No.	Natural England's Relevant Representation -Appendix A - Generic Issues	RAG status Rel and WR Rep	Consultation, actions, progression	RAG status D1	Consultation, actions, progression	RAG status D2	Consultation, actions, progression	RAG status D3
Appendix A - Generic Issues								
1	We have continued concerns that not all the risks related to the proposal have been fully considered which means that, following the precautionary principle, we are unable to exclude, beyond all reasonable scientific doubt, no Adverse Effect on Integrity of the Wash SPA or The Wash & North Norfolk Coast SAC.		NE has advised the Applicant (in writing through our DAS service on 13th Sept) that unless the further information is provided to help determine the scale of the impacts, we will not be able to advise further on the appropriateness of any mitigation and/or compensatory measures and our advice will be more precautionary.		Ongoing		Ongoing

No.	Natural England's Relevant Representation - Appendix B - Offshore Ornithology	RAG status Rel and WR Rep	Consultation, actions, progression	RAG status at D1	Consultation, actions, progression	RAG status D2	Consultation, actions, progression	RAG status D3
Appe

**Plate A1- 3 Mitigation measures proposed for the Habitat Mitigation Area**

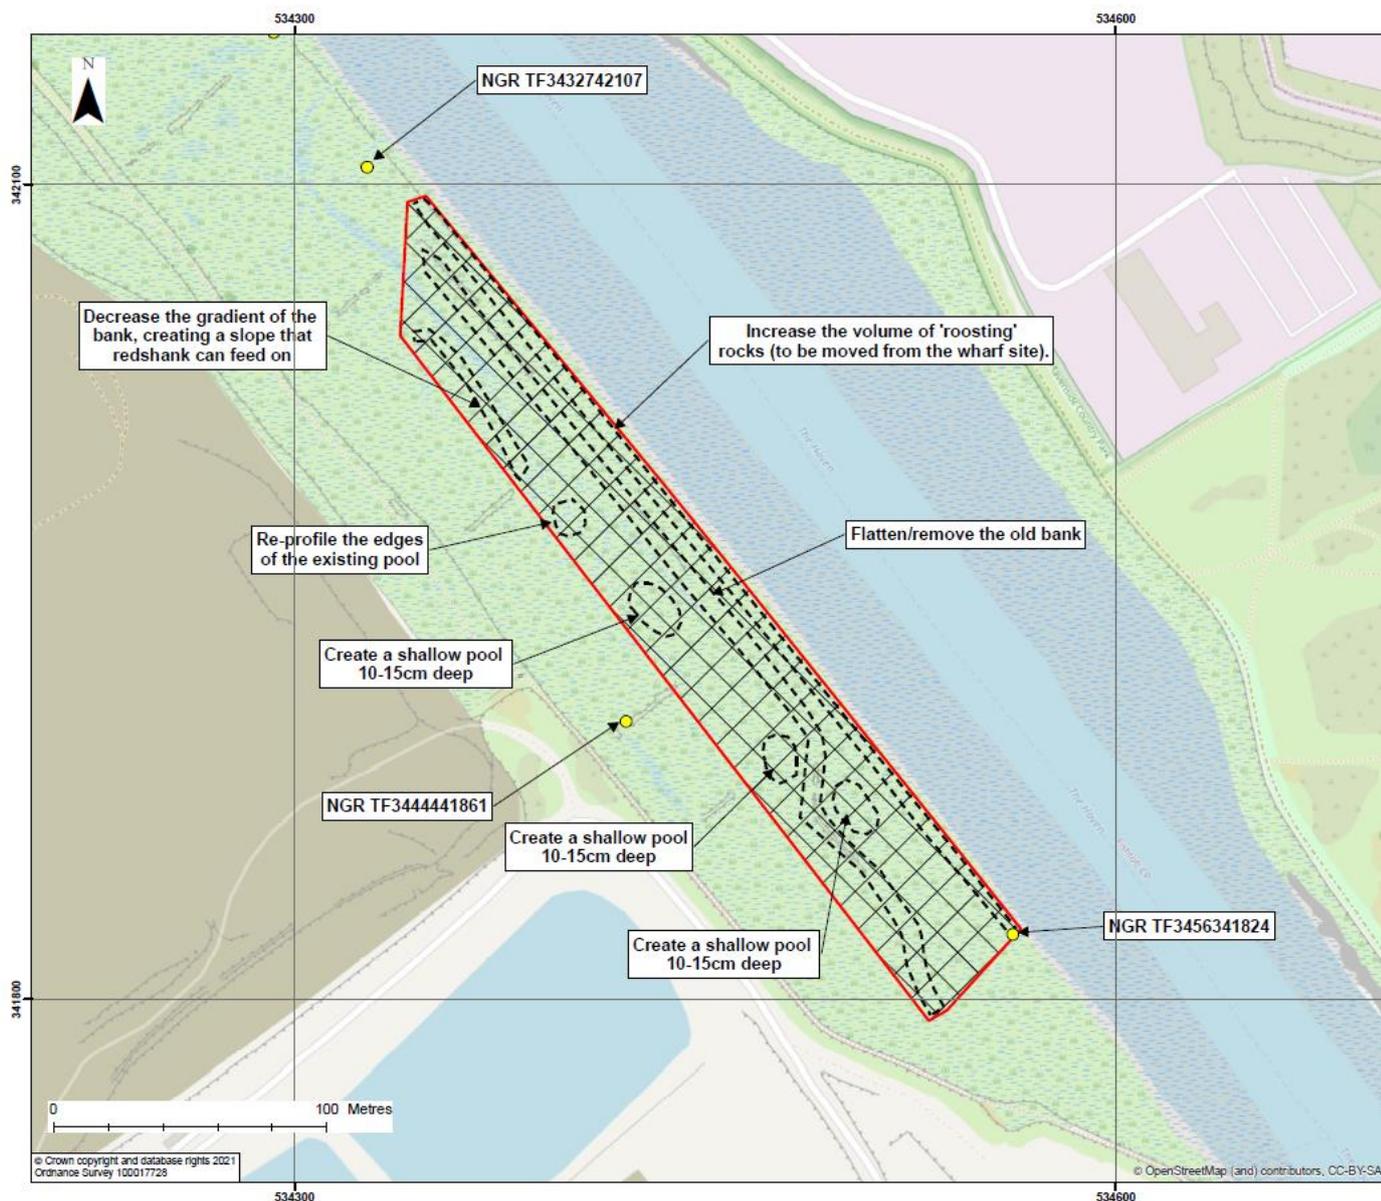
No.	Natural England's Relevant Representation - Appendix B - Offshore Ornithology	RAG status Rel and WR Rep	Consultation, actions, progression	RAG status at D1	Consultation, actions, progression	RAG status D2	Consultation, actions, progression	RAG status D3
Outline Landscape and Ecological Mitigation Strategy								
23	Natural England advises that there appears to be an omission of mudflat and saltmarsh from calculations, which need addressing given this is also supporting habitats/functionally linked land for SPA birds.		NE awaits an updated OLEMS.		NE awaits an updated OLEMS.		NE awaits an updated OLEMS.	
24	Is saltmarsh being classified as intertidal here in appendix 1 of the OLEMS?		NE awaits an updated OLEMS.		NE awaits an updated OLEMS.		NE awaits an updated OLEMS.	
25	Summary of proposals for roost compensation: We advise that proposals need amending to reflect the need for annual habitat management and the need to manage disturbance (both people and boats) if this is to work. Ownership of (any) shooting rights is important to know and not articulated.		NE awaits an updated OLEMS.		NE awaits an updated OLEMS.		NE awaits an updated OLEMS.

26	Mudflat compensation 'not negotiated yet': we advise that there are no guarantees that the mudflat as a habitat will be suitable for foraging redshank; as not negotiated no certainty of delivery.		NE awaits an updated OLEMS.		NE awaits an updated OLEMS.		NE awaits an updated OLEMS.	
Environmental Statement - Habitats Regulations Assessment

31	Natural England advises that the current description of proposed works to compensate for loss of habitat important to redshank is insufficient to have confidence that it will deliver the necessary compensation at the scale required.		NE await updated documents (addendum to HRA and OLEMS).		Natural England awaits consultation on a compensation package.		Please see Appendix J1 at Deadline 3 for NE's advice on compensation.

No.	Natural England's Relevant Representation - Appendix C - Intertidal and Marine Ecology	RAG status Rel and WR Rep	Consultation, actions, progression	RAG status D1	Consultation, actions, progression	RAG status D2	Consultation, actions, progression	RAG status D3
4	<p>Under the Habitat Mitigation Works within the Habitat Mitigation Area it mentions 4 shallow pools (max 15cm deep) created in the existing saltmarsh. Natural England is concerned that without maintenance these will quickly silt up. Therefore, we query what ongoing management will be needed to maintain these pools? Is the intention for these pools/ scrapes to remain unvegetated? Area of the 4 pools? Will the scrapes/ pools result in direct loss of further saltmarsh vegetation? Has this been calculated? this information is vital to assess the benefits of the proposed new area.</p>		<p>Please see issue 22b in the Offshore Ornithology section.</p>		<p>Please see issue 22b in the Offshore Ornithology section.</p>		<p>Please see Appendix J1 at Deadline 3 for NE's advice on compensation.</p>

No.	Natural England's Relevant Representation - Appendix C - Intertidal and Marine Ecology	RAG status Rel and WR Rep	Consultation, actions, progression	RAG status D1	Consultation, actions, progression	RAG status D2	Consultation, actions, progression	RAG status D3
5	Natural England notes that works in the Habitat Mitigation Area will be undertaken outside the overwintering bird period; and queries if can this also include outside the breeding bird period to minimise impacts (disturbance and physical) on ground nesting birds. Works should ideally be undertaken in August/ early September. Natural England requires further clarity and commitments on how impacts to breeding birds will be avoided, reduced, and mitigated.		The Applicant informed NE that "Maintenance will be discussed in the updated OLEMS document to ensure ongoing management of the Habitat Mitigation Area to ensure that it functions as required to mitigate the impact." NE queries how this mitigation will be secured?		No update		NE awaits an updated OLEMS.
